**From:** [REDACTED]  
**To:** [Planning Comments \(Shared Mailbox\)](#)  
**Cc:** [REDACTED]  
**Subject:** Objection to Application Ref: 6/2023/2089/HOUSE - Freny Cottage 41 Northaw Road East Cuffley, EN6 4LU  
**Date:** 01 November 2023 09:37:01  
**Importance:** High

**Re: Second Application. Reference: 6/2023/2089/HOUSE  
Proposed Development at: Freny Cottage 41 Northaw Road East, Cuffley, Potters Bar EN6 4LU (the "Application")**

Proposal existing layouts and elevations

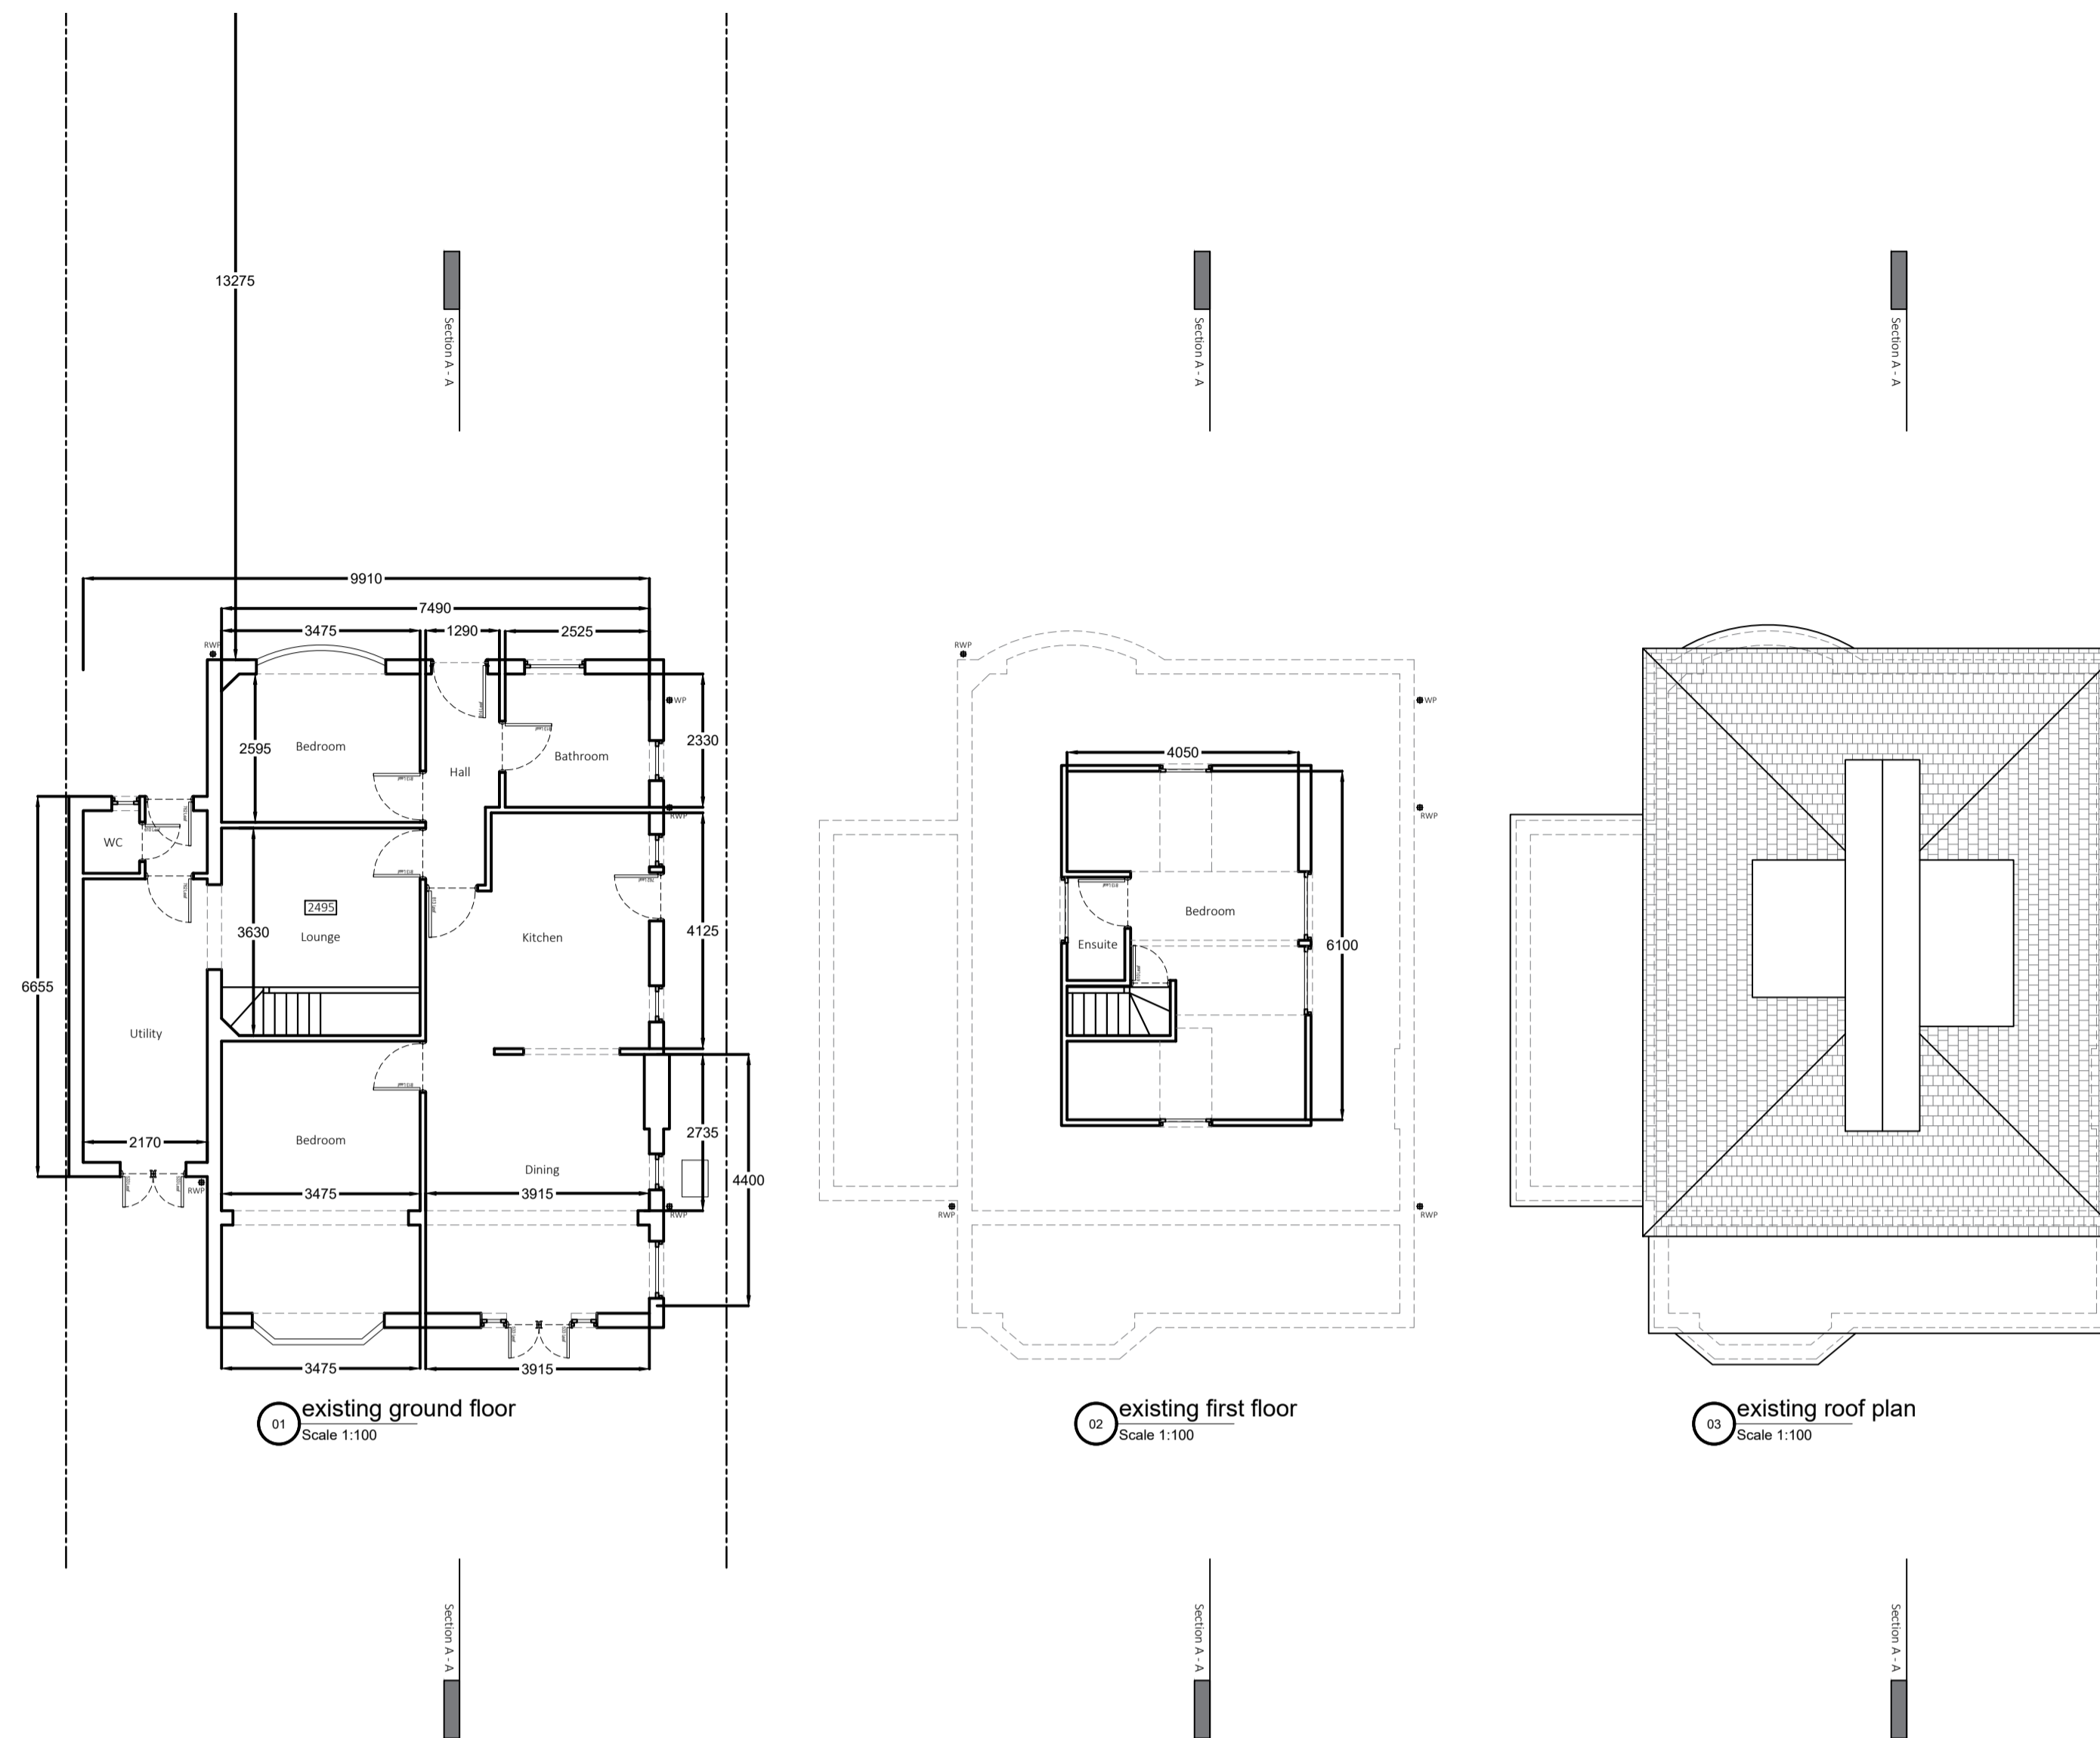
Has the change in ridge height been measured off the same point in both the 'Existing' and the 'Proposed' submitted drawings? It is hard to judge, but there appears to be a different point of measuring in each drawing.
